RE: The Beach at Woodmoor, PUD Development Plan (PUDSP-17-002) - 1st Review Response

This letter responds to your June 26, 2017 review letter relating to the above referenced project. Responses to review comments are shown in **RED** below.

The Beach at Woodmoor Filing No. 1
 Coronado Beach Drive -- Plan and Profile
 Sanitary Sewer -- Plan and Profile
 El Paso County, Colorado

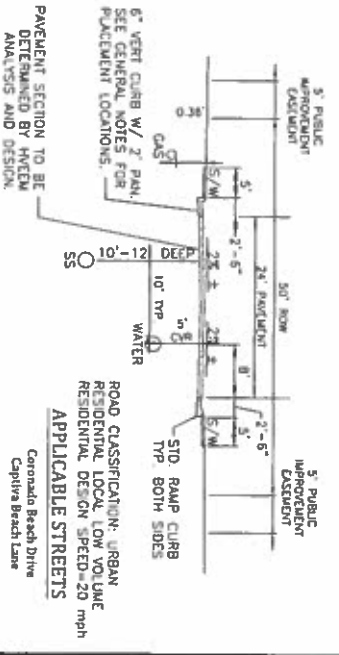
5. Manholes are required at minimum every 500 linear feet for sewer mains per the District's system specifications. Please ensure this requirement is met along Coronado Beach Drive.

A meeting was held with WWSD and all issues have been addressed in the resubmittal.

The Beach at Woodmoor Filing No. 1
Utility System Plan
El Paso County, Colorado

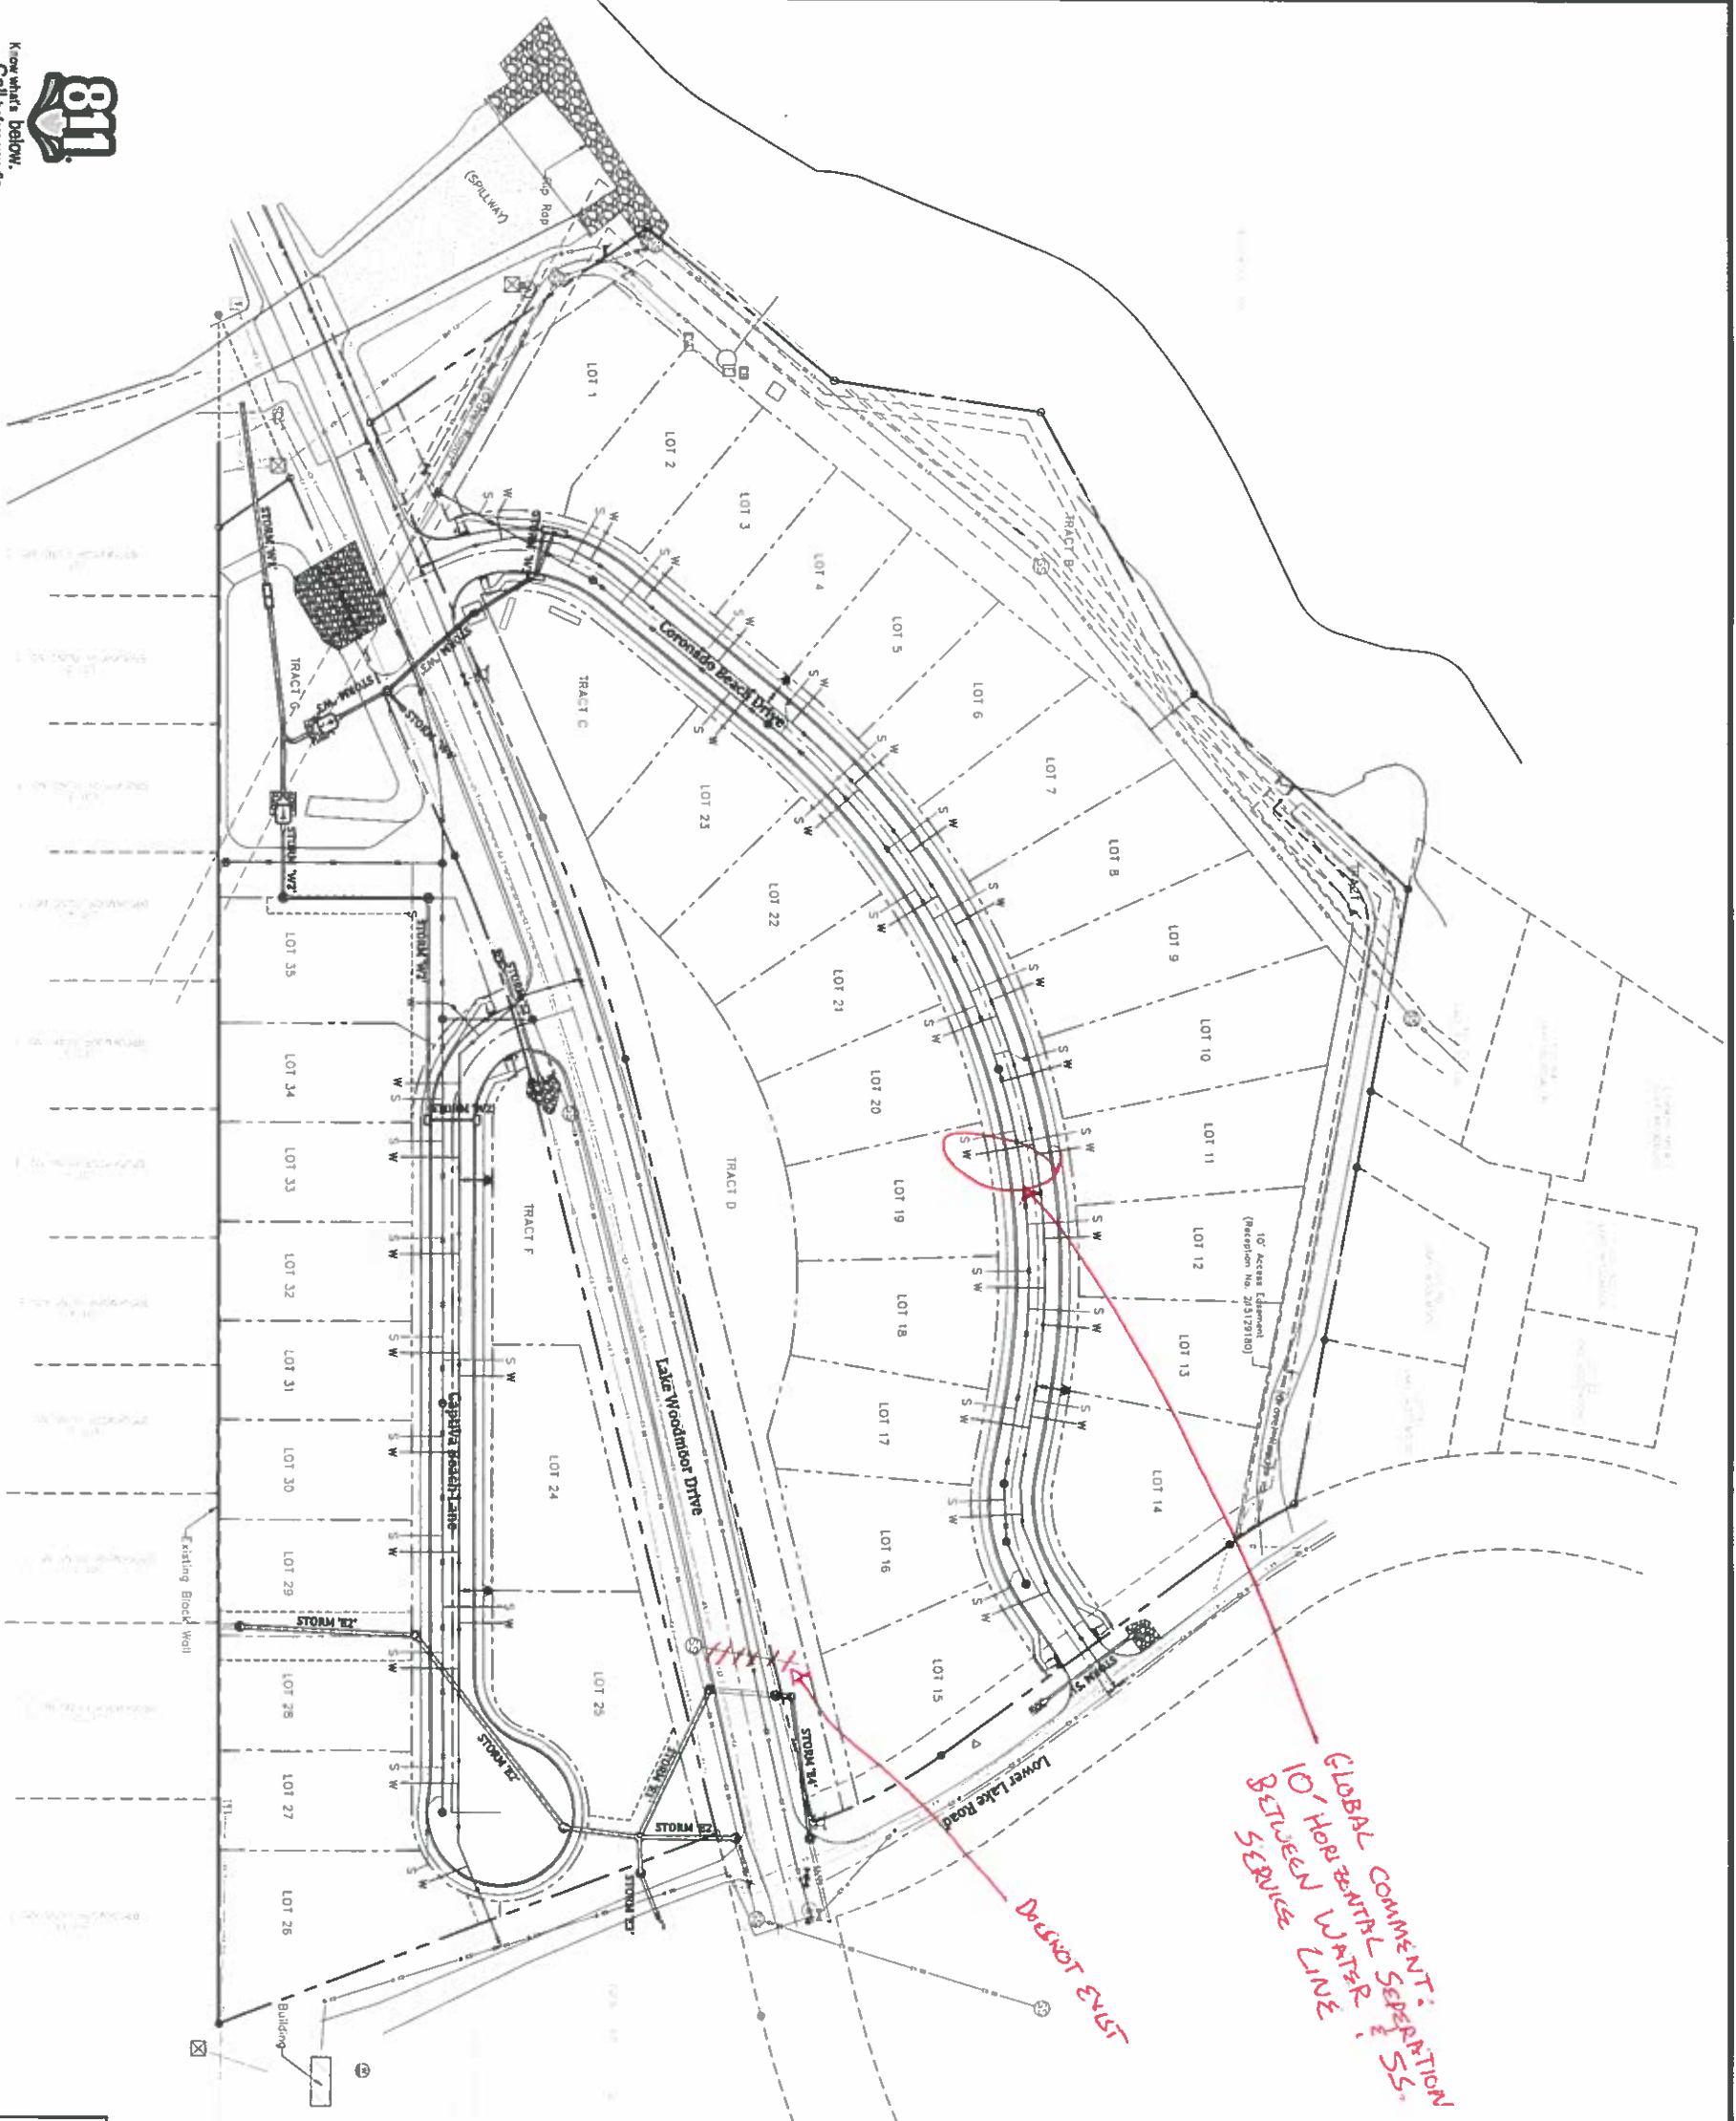
1. The curvilinear sanitary sewer line from Captiva Beach Lane across Lot 35 violates the District's system specifications because it is non-tangential. As possible, the District avoids curvilinear sewer lines and an easement twice as wide as the main is deep would be required around the proposed route. Please note the alternative route the District proposes, in accordance with our system requirements, between Lot 33 and 34 with easement (not to scale) for the District depicted on the attached marked drawing.

2. There are no fire hydrants shown south of Lake Woodmoor Drive along Captiva Beach Lane. Please consult the applicable fire department with jurisdiction over this development regarding spacing and location of fire hydrants and add hydrant locations to plan.

3. The District requires a minimum of 6 feet of cover for all mains measured from the finished grade to the top of the main. Please confirm the grading plan for Tract H maintains this minimum cover requirement for the existing sewer main in this proposed lot.

4. The District is concerned about adding a fourth connection from the northwest to the manhole in Lake Woodmoor Drive. Please terminate proposed Coronado Beach Drive sanitary sewer main on north side of Lake Woodmoor Drive. Reference the attached marked drawing.

6. Riprock (End FES) at STA 10+00 North of Tract H interferes with the existing sanitary sewer manhole risking storm water infiltration to the District's sewer infrastructure Developer's engineer will need to evaluate relocating riprock or relocation of existing sanitary sewer manhole.
